CITY OF ALBUQUERQUE

November 16, 2021

Re: Rockwell Office/Warehouse
1601 Airtech Ct Se
Traffic Circulation Layout
Architect's Stamp 11-09-2021(N15-D010A)

AS-100

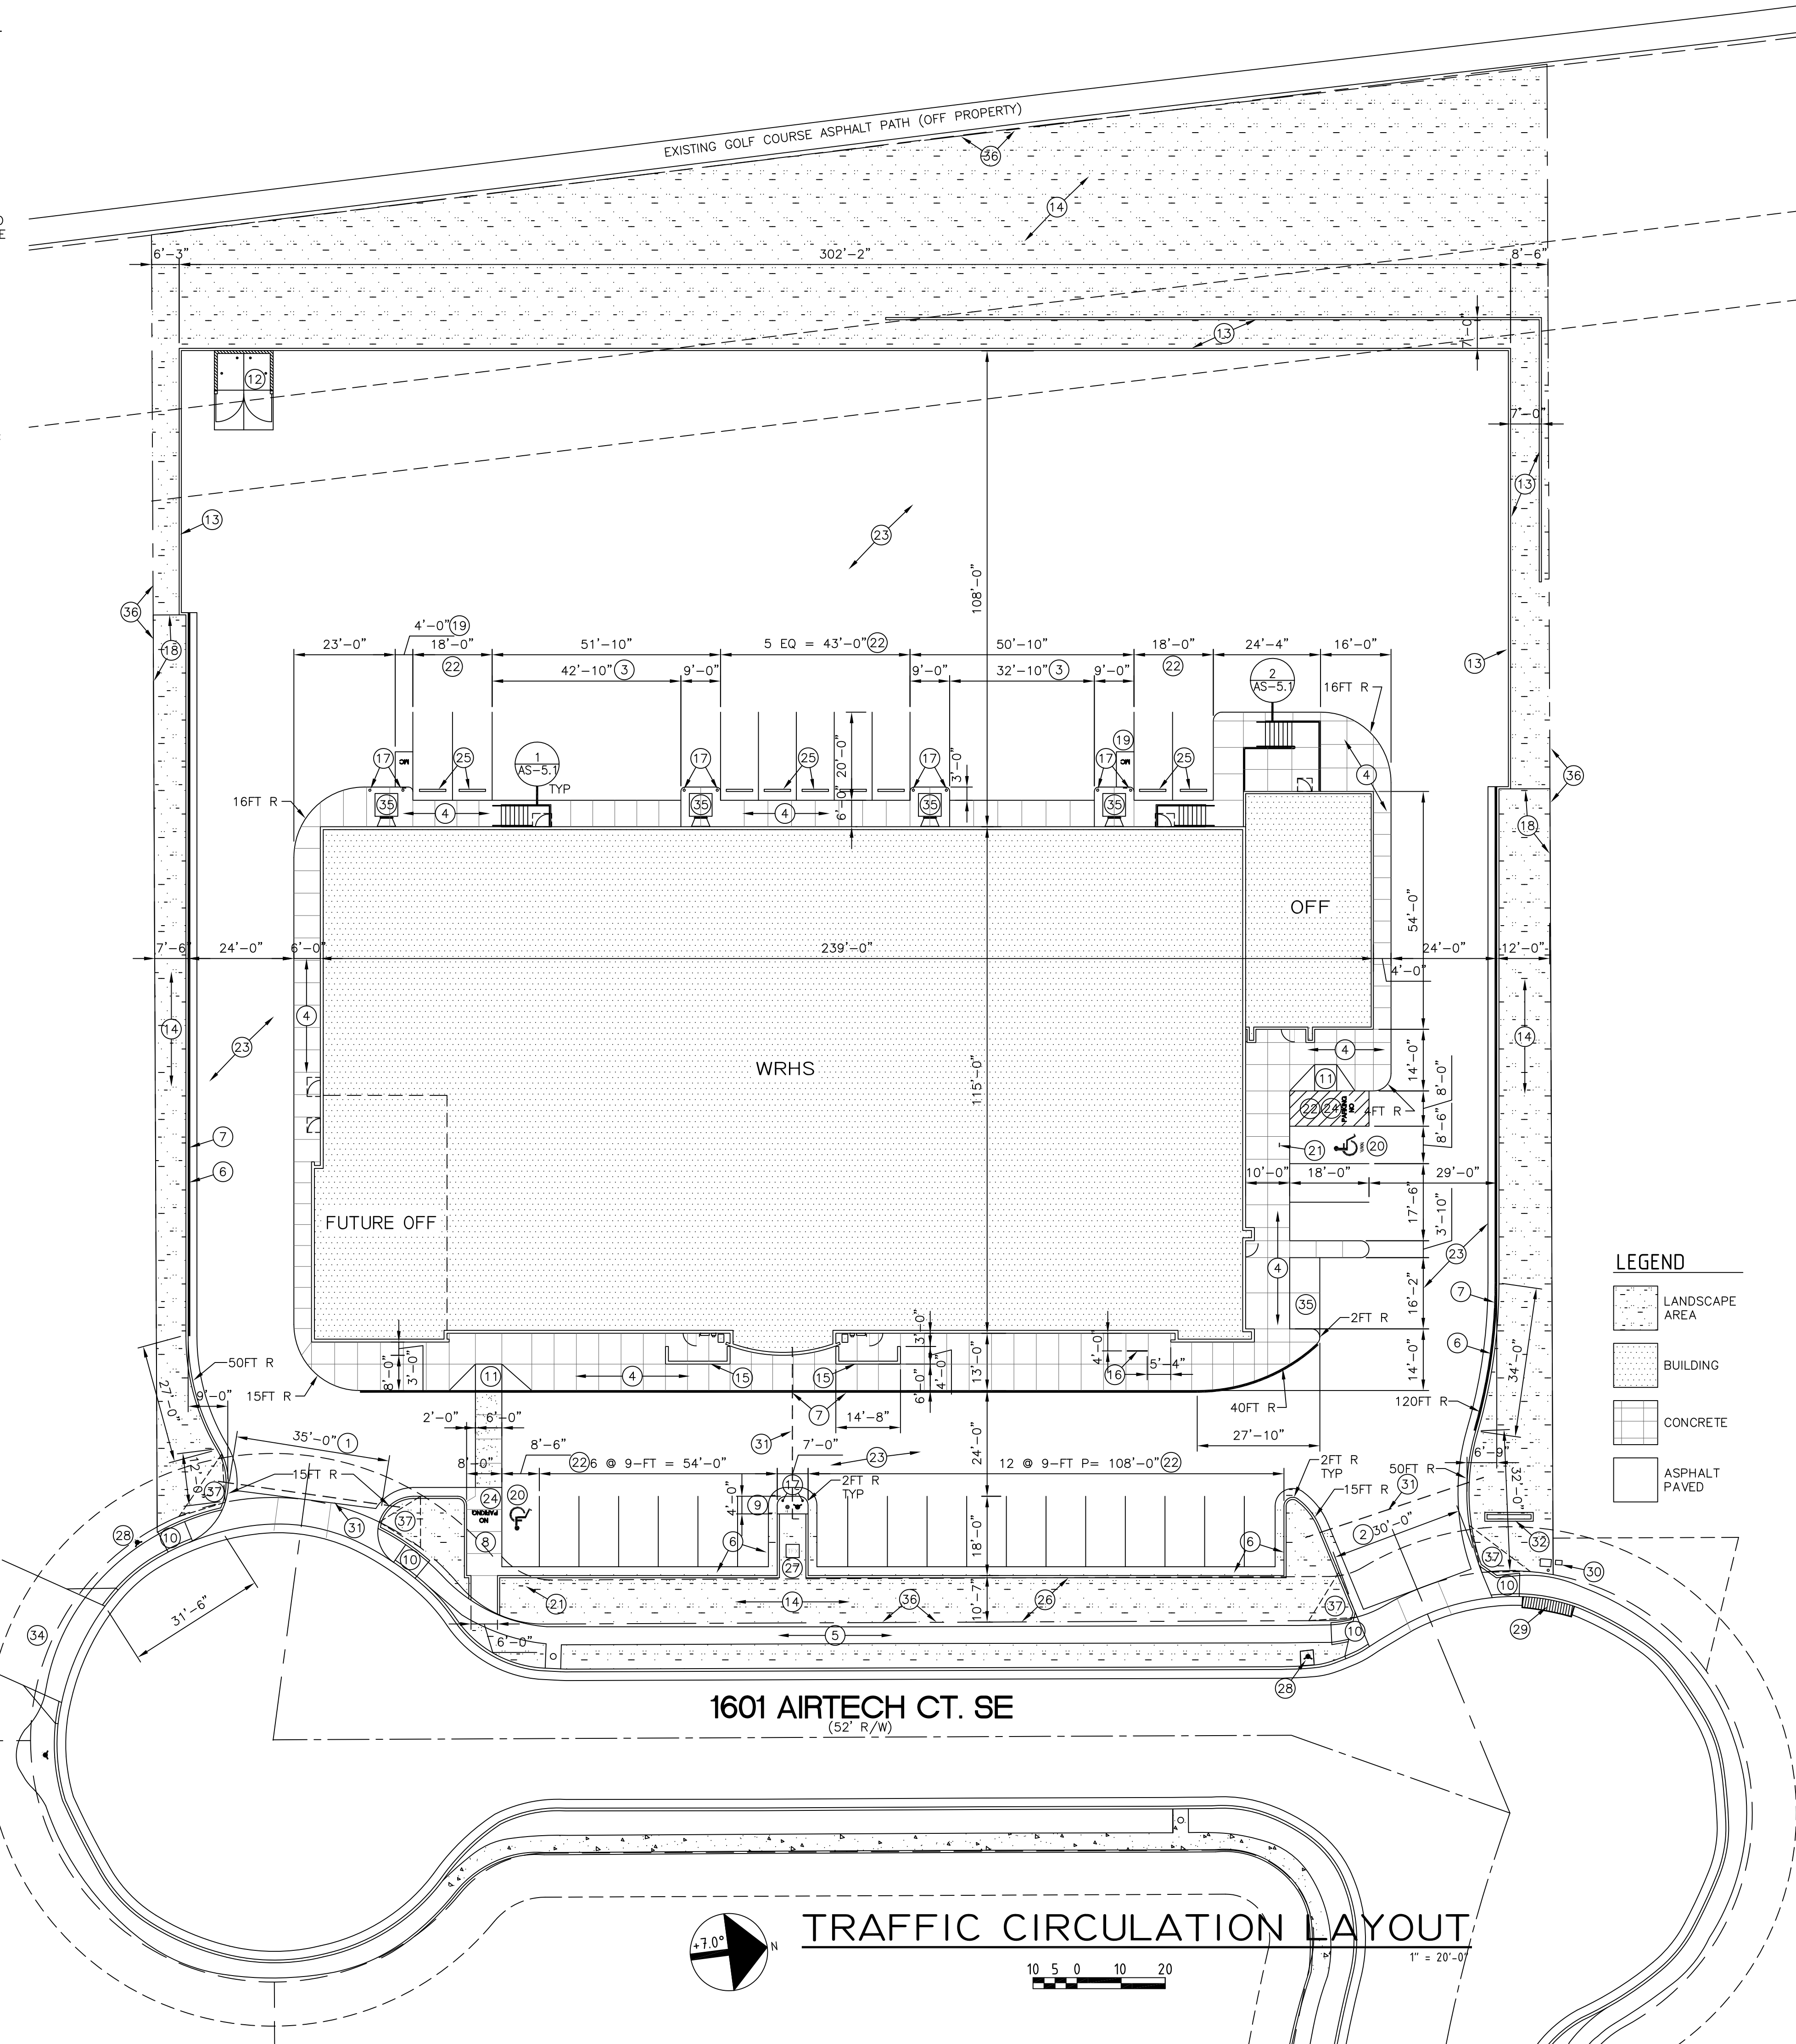
1. Listed are the number of parking spaces required by the IDO as well as the proposed number of parking spaces including bicycle and motorcycle parking.
Coordinate/discuss with Zoning.

2. **Airtech Ct. frontage:**
 - The existing sidewalk needs to be shown from property to property line and existing width provided.
 - Show that proposed ramp on the southern and northern left are not encroaching onto adjacent land owner. If it is then you will need land owner permission (letter). This is per DPM design Criteria requirements on drive ways.

3. Keyed Note 11: This type of proposed ADA ramp is not allowed since it is not ADA compliant. Please reflect an appropriate symbol to define ramps and detail to assure there is not safety impacts even though you referenced COA std dwgs the ramp symbol and proposed layout is not ADA compliant. Address.

4. Keyed Note 20: Remove reference COA std dwg 2426 (this standard drawing is for private entrance design:).
5. Keyed Note 33: Provide note that proposed monument sign will be located private property including air space.

6. Maximum access width for arterial, collector, and local streets are as follows:
 - Explain why both entrances don't comply with the criteria for local streets?

7. Motorcycle parking spaces shall be designated by its own conspicuously posted upright sign, either free-standing or wall mounted per the zoning code (reference G/AS-5).

12. Per the IDO, a 6 ft. wide ADA accessible pedestrian pathway is required from the public sidewalk to the building entrances. Please clearly show this pathway and provide details.

13. Per DPM, a 6 ft. wide ADA accessible pedestrian pathway is required from the ADA parking stall access aisles to the building entrances. Please clearly show this pathway and provide details.

14. **ADA accessible pedestrian pathway should not be placed behind parking space or adjacent to a vehicular way. Vehicle and pedestrian/wheel chair conflicts should be avoided as much as possible.**

17. Show the clear sight triangle and add the following note to the plan: "Landscaping and signage will not interfere with clear sight requirements. Therefore, signs, walls, trees, and shrubbery between 3 and 8 feet tall (as measured from the gutter pan) will not be acceptable in the clear sight triangle.
